Interested Party BIOFUELWATCH IP NO 20032287 submits the following comments on the representation by the Environment Agency on Drax's BECCS application.

Interested Party BIOFUELWATCH IP NO 20032287 submits the following comments on Representation RR-141 from UK Health Security Agency (UKHSA) and the Office for Health Improvement and Disparities (OHID).

Interested Party BIOFUELWATCH IP NO 20032287 submits the following comments on the Representation by Natural England.

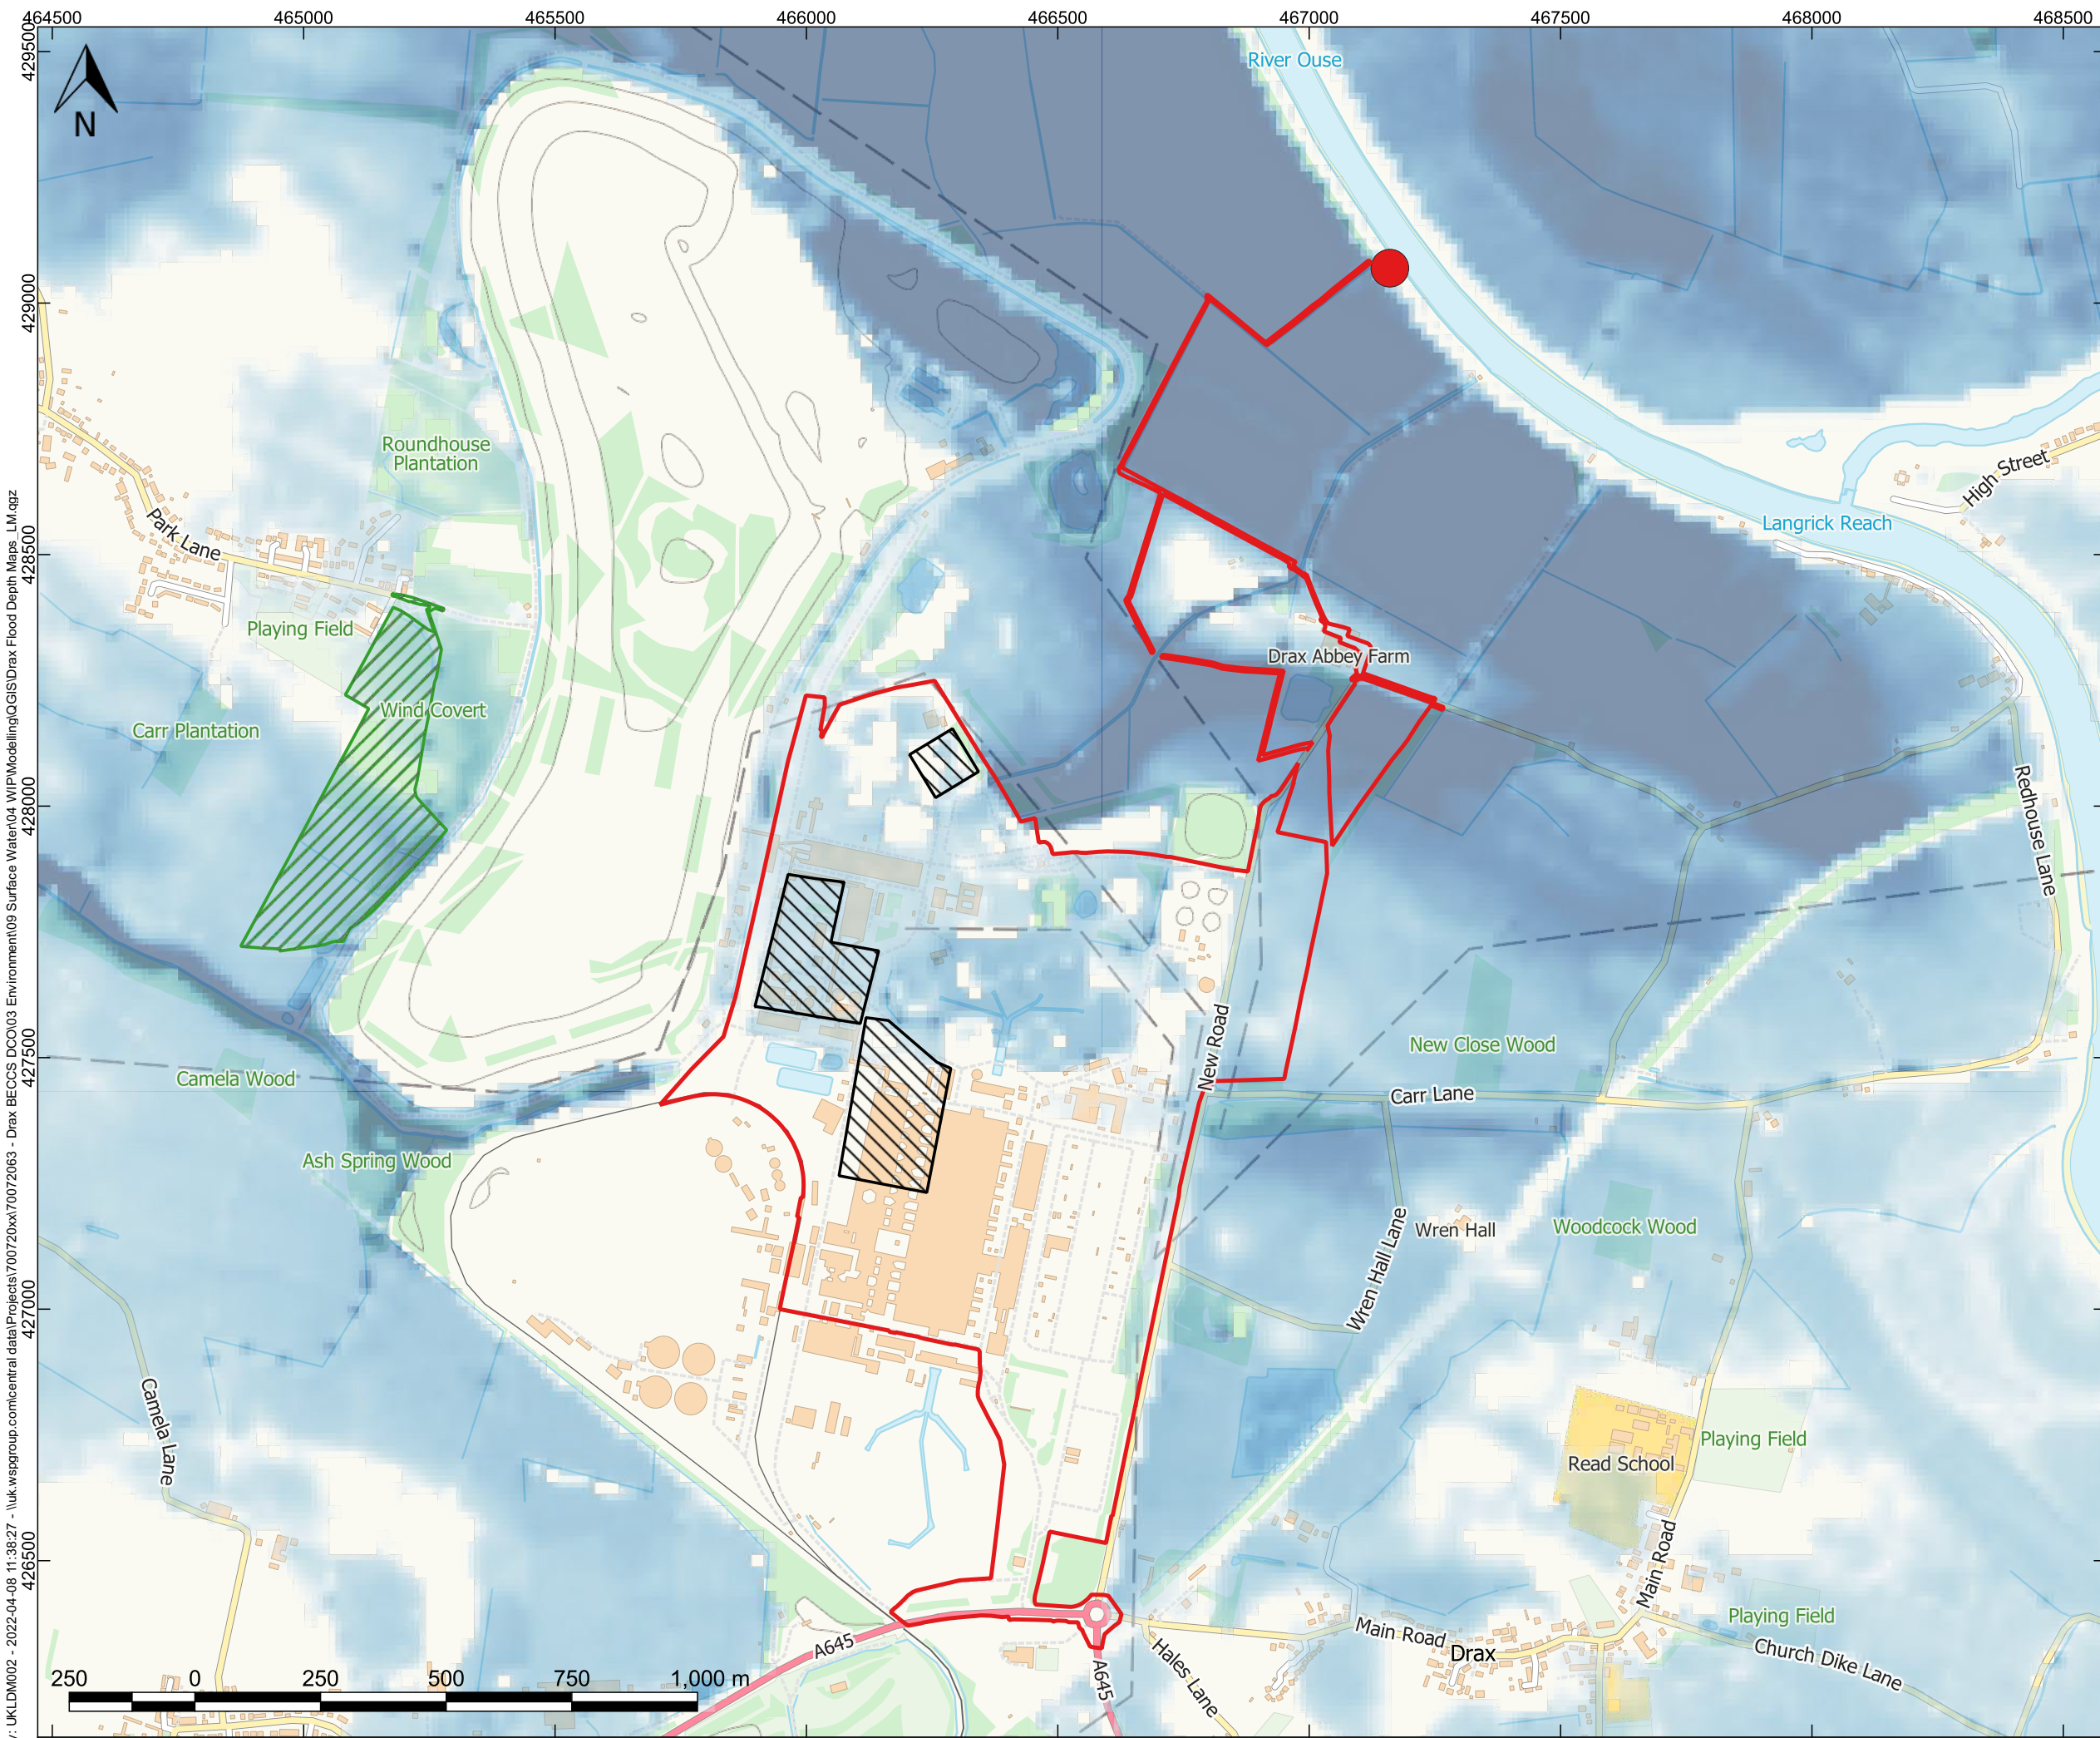
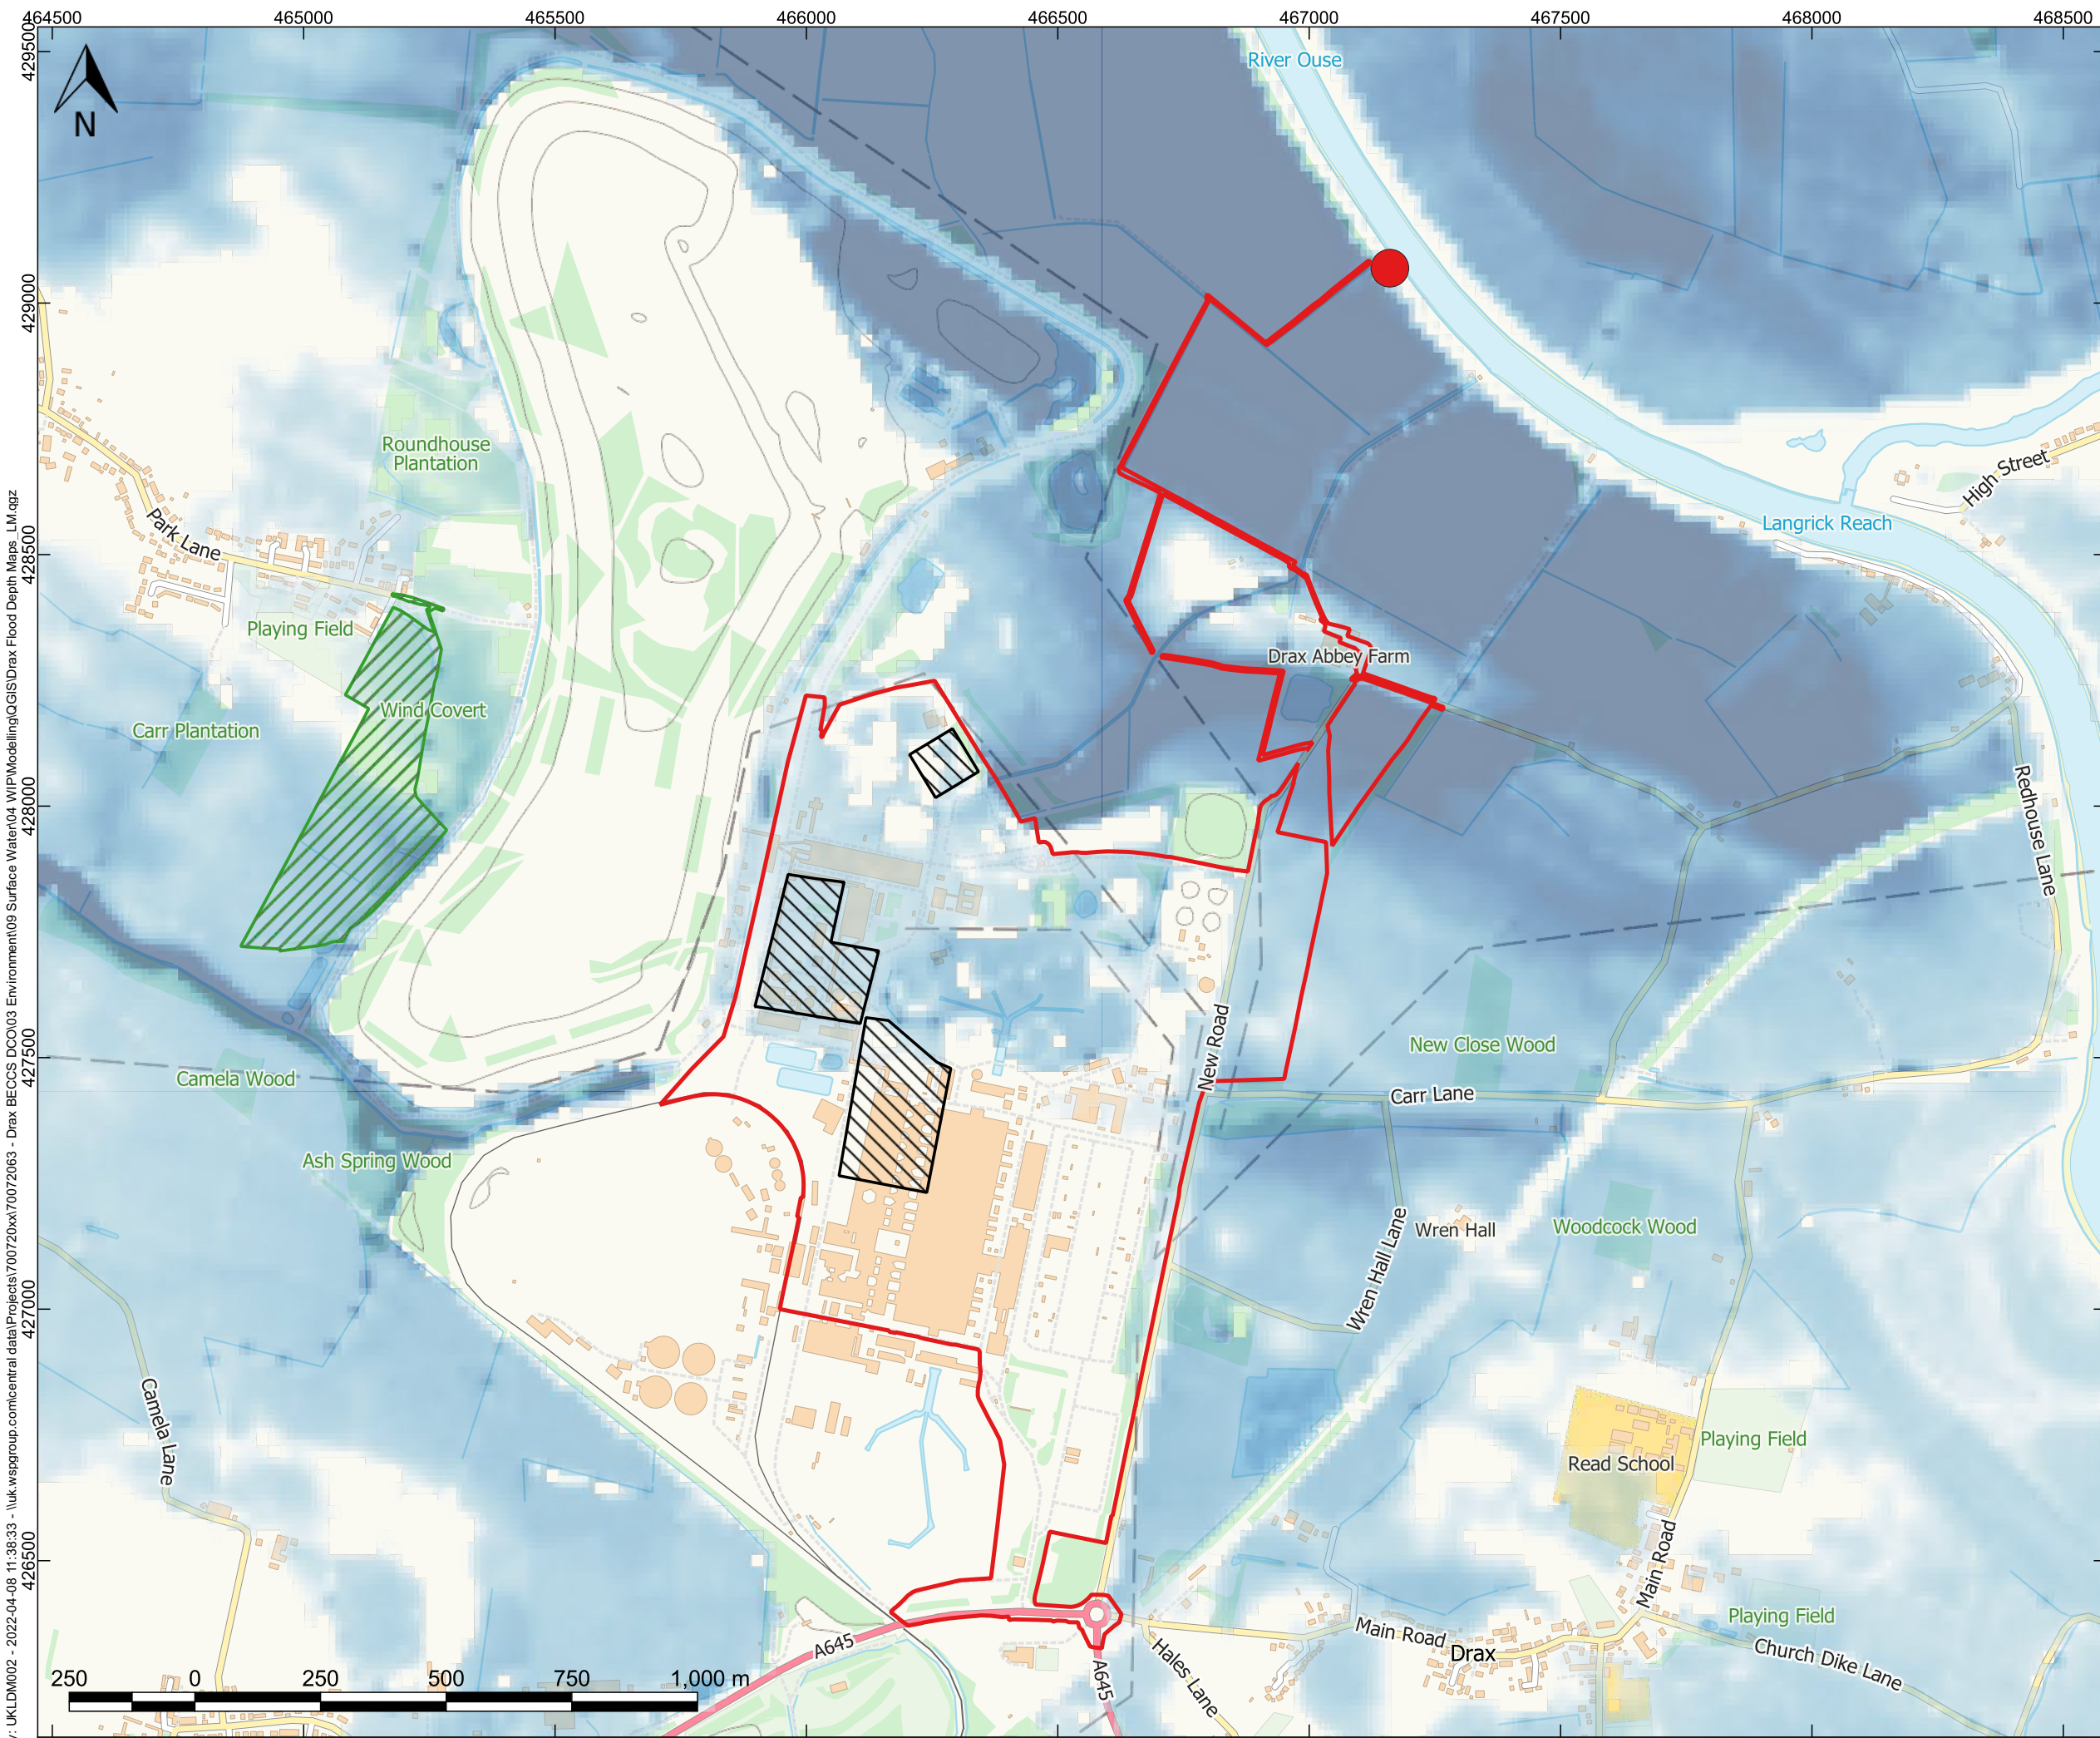
We understand that the applicant is currently in discussions with the EA to resolve outstanding issues around flooding, however, there are some pertinent issues to be raised. Firstly, the latest Climate Change Risk Assessment policy paper (CCRA 2022) advises that climate change adaptation must be integrated effectively into all new infrastructure and that “the evidence shows that we must be prepared for warming up to 4°C” (CCRA 2022: 3). This means an increasing flood likelihood of 44% by 2050 and 75% by 2080. The 4°C global warming scenario is not taken into account by the Flood Risk Assessment document.

We also note that scientists have raised the near term warming projections this year, as well as the proximity to tipping points which include polar ice and glacier melt (impacting on sea levels). To provide a realistic Flood Risk Assessment, these additional factors should also now be taken into account.
